RE: Mixed Use Development, Site 3 (Stages 2 &3), Sydney Olympic Park MP 10_0027

I refer to the Environmental Assessment for the above Major Project Application, which was referred to Sydney Olympic Park Authority (the Authority) for comment. The following comments are made on the proposed development, based on issues that the Authority requires further involvement from the applicant.

SOPA DRP Advice Sheet - 27th May 2010

Rooftop Planting

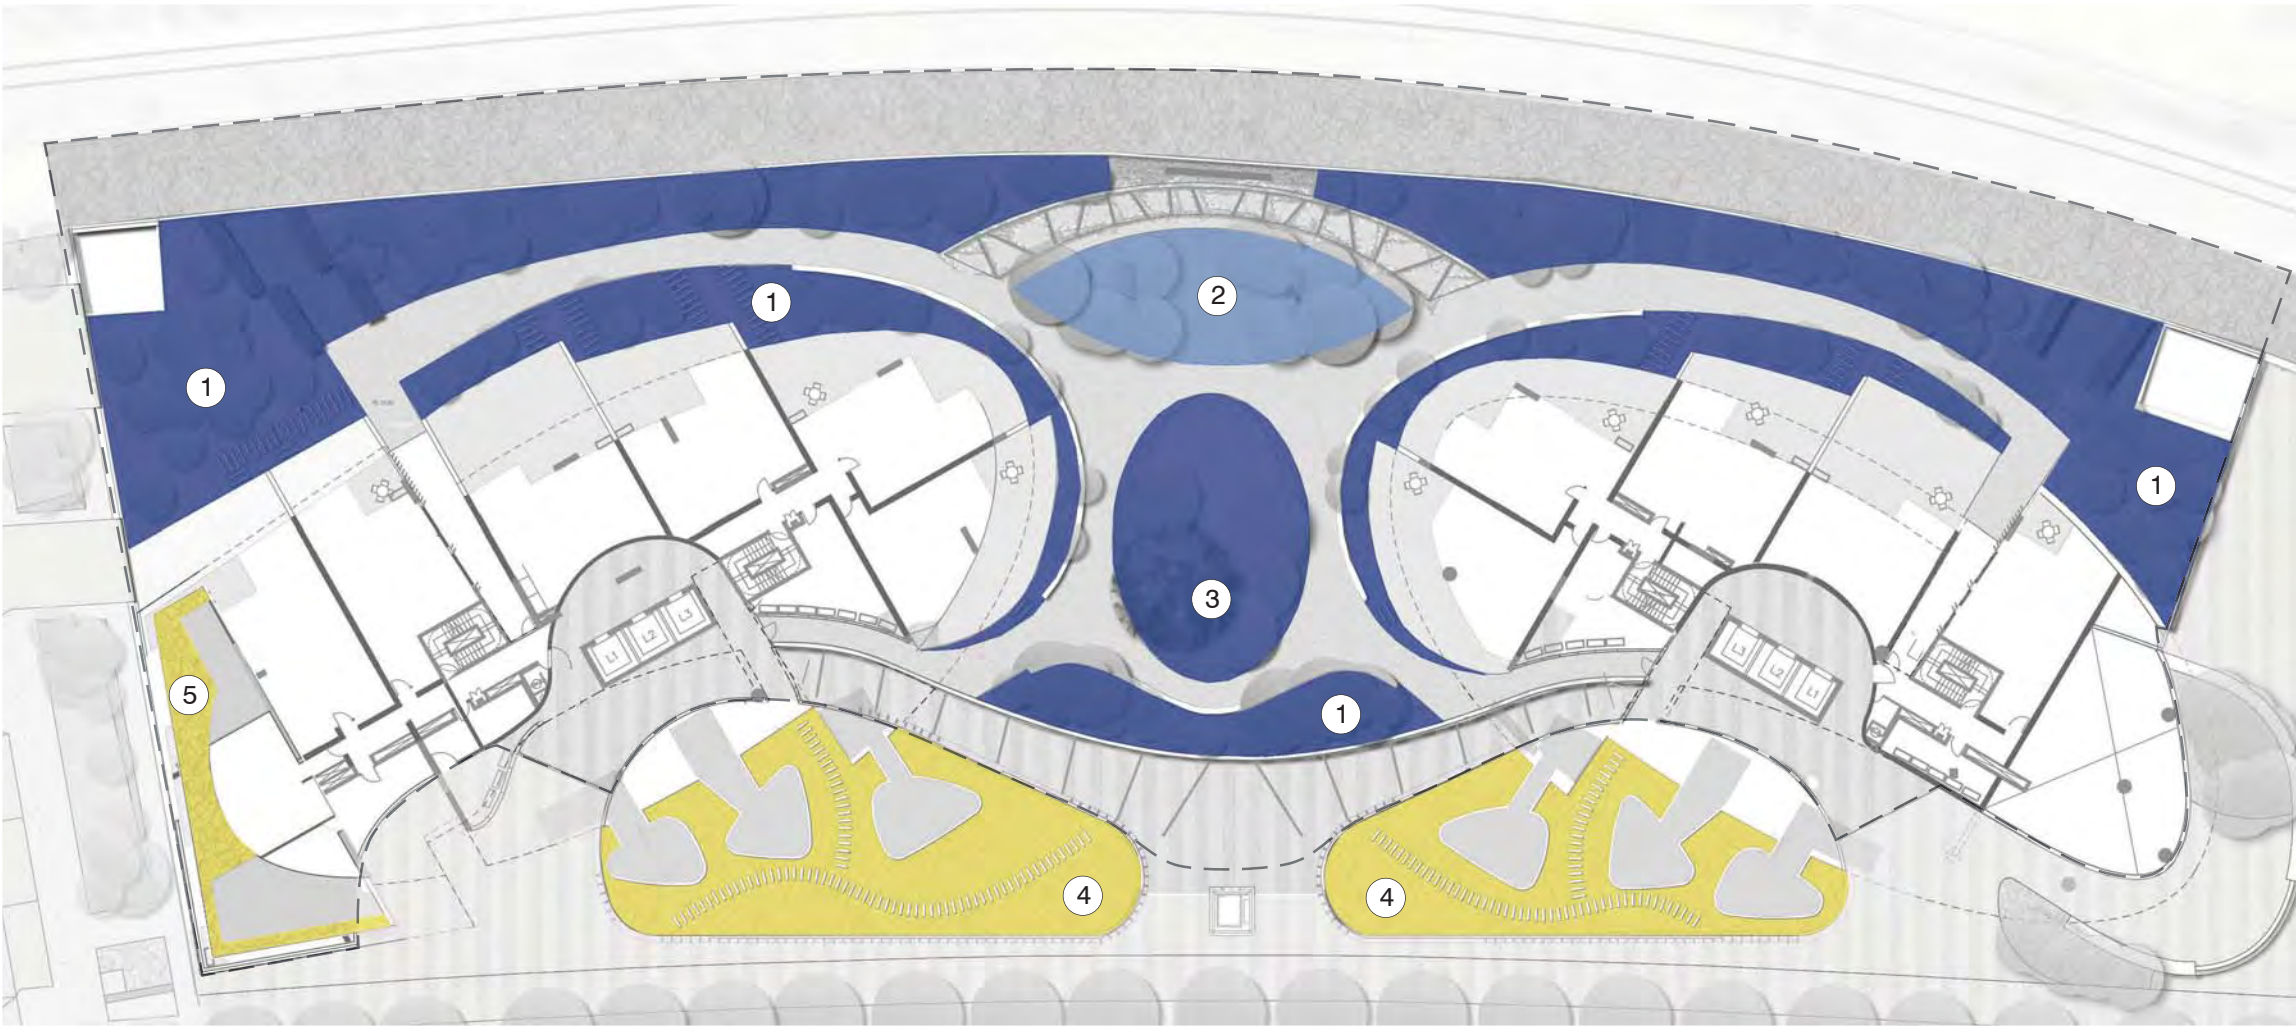
10. The proposed RSZ height (Tower 1 is 5.88m high; Tower 2 is 6.1m high) with minimal to nil setback from the respective tower parapets do not comply with MP 2030. The RSZ should have a maximum height of 5m and setback 3m (minimum) from the parapet in accordance with MP 2030. The non-compliance with the SEPP MD 2005 building height limit means that compliance with the RSZ requirement must be achieved.

Further details should also be provided in relation to the coverage in plan of the respective RSZ.

Storage Provision
=3m3

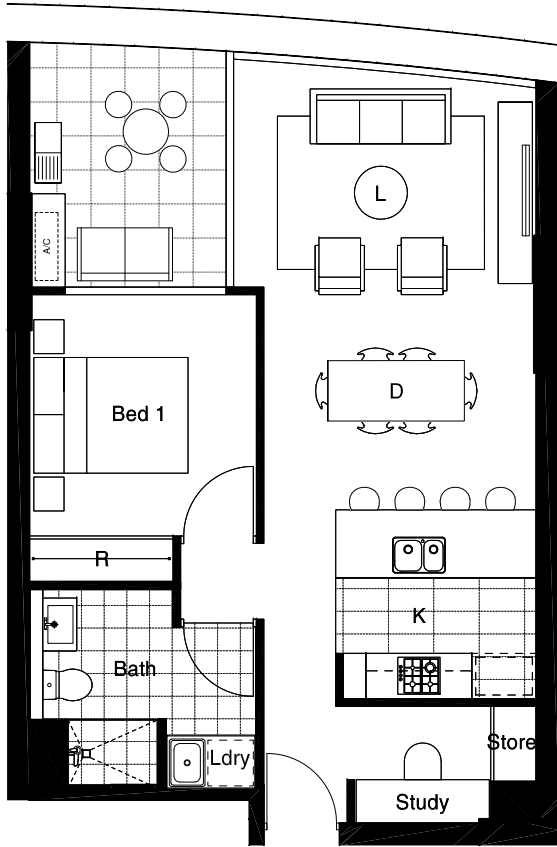
28. It appears that some units on each floor appear do not meet the minimum room size requirement of MP 2030 & the RFDC, when consideration of internal storage requirement is taken into account. Further, it appears that some units have not been provided with internal storage space. These matters are to be addressed.
29. The total residential storage (internal and external) allocation to each unit is unclear. Compliance with MP 2030 & RFDC requirement for storage should be confirmed.
30. Some balconies on each floor (including podium level) appear to not meet the minimum size/dimension requirements of MP 2030 & the RFDC.
